KIRKLEES METROPOLITAN COUNCIL INVESTMENT & REGENERATION SERVICE

DELEGATED DECISION TO DETERMINE APPLICATIONS FOR CONSENT, AGREEMENT OR APPROVAL REQUIRED BY CONDITION

Reference No:	2025/44/91372/E
Site Address:	land northwest of, Urban Terrace, Denby Lane, Grange Moor, Huddersfield, WF4 4EB
Description:	Discharge of details reserved by conditions 9 (Construction Management Plan), 17 (Bin Storage Enclosures), 18 (Waste Storage), 19 (Construction Traffic), 20 (Highway Condition Survey), 22 (Arboricultural Method Statement), 24 (Boundary Treatments), 26 (Crime), 27 (Hard and Soft Landscaping), 28 (Cycle Parking), 29 (Electric Vehicle Charging), 30 (Construction Environmental Management Plan: Biodiversity) on previous permission 2023/93704 for erection of 12 dwellings and associated works
Recommending Officer:	William Simcock

Officer Report

Figure 2: Temporary fence location.

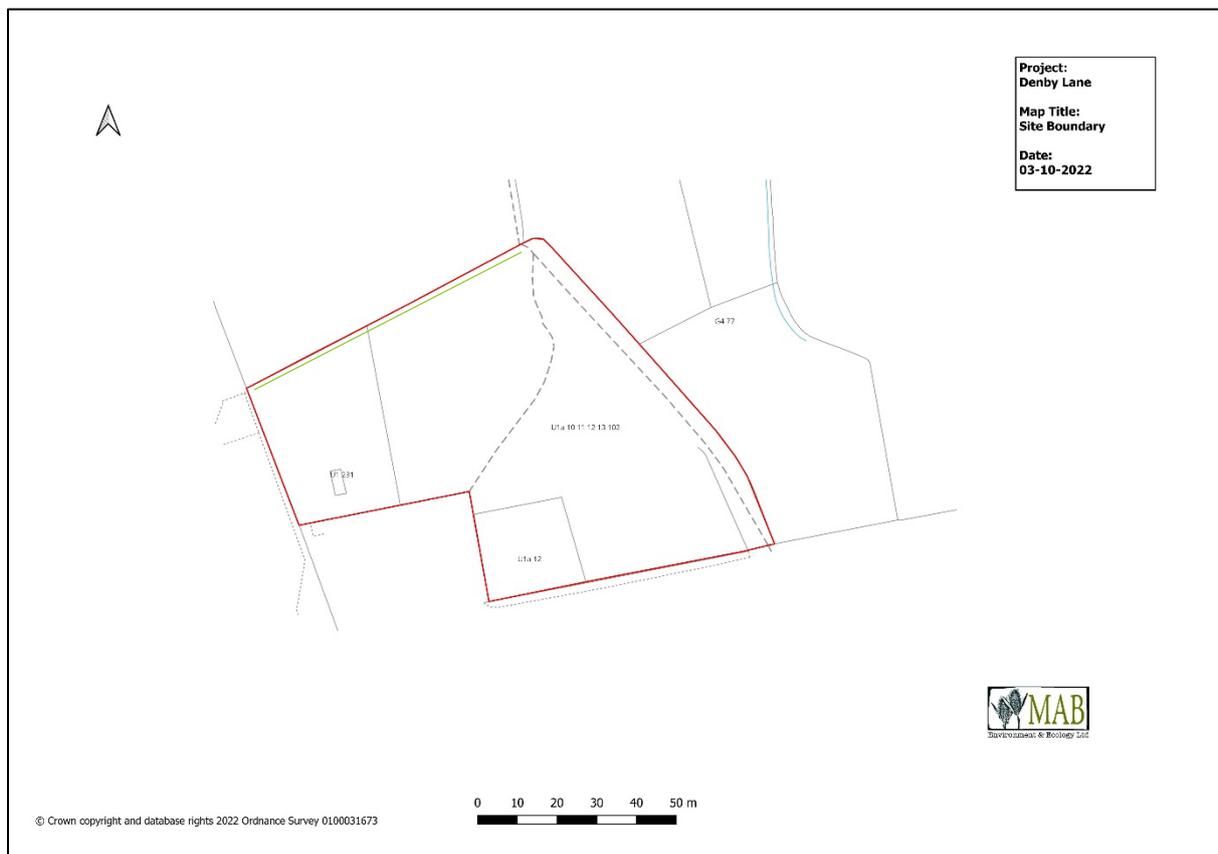
The report states that prior to the commencement of any works on the northern boundary of the site, temporary fencing will be erected 2m inside the northern boundary to avoid disturbance to this area and reduce the risk of fauna such as hedgehog entering the construction zone. The ecologist has explained in email correspondence with the case officer that this precaution is deemed appropriate because of the tree belt and large domestic garden that lies to the north of the site.

The submitted CEMP: Biodiversity has been examined by KC Ecology in their consultation response dated 19/06/2025, where they confirm that it fulfils the purposes of the condition.

Proposed Cycle Store Location Plan
1 : 250

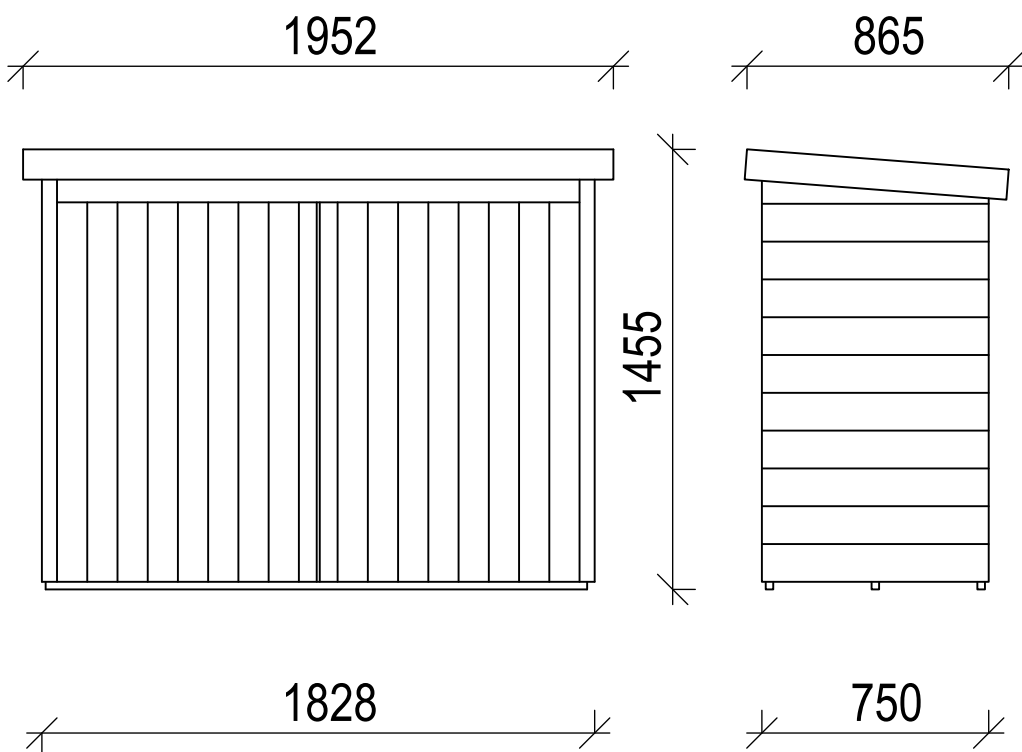
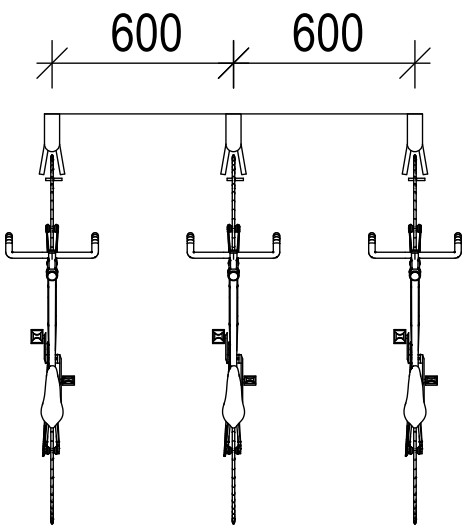
- 22D26-FBA-ZZ-XX-DR-A-0723-P07 - Proposed Cycle Store Plan.
- Moravia wall-mounted bike rack specification sheet.
- Timber bike shed specification sheet.

Plots 1-2 and 5-9 are shown to have a cycle rack mounted within their respective garages. This is acceptable.

The agent has confirmed that the timber bike stores do not have any windows. KC DOCO has requested more detail on locks for the bike sheds – the specification sheet does however confirm that these are to be of hasp and staple type (i.e. requiring a padlock). It is considered that the degree of security provided by the proposed cycle sheds would give future residents an acceptable degree of protection from crime.

Officers therefore recommend that the submitted details be approved.
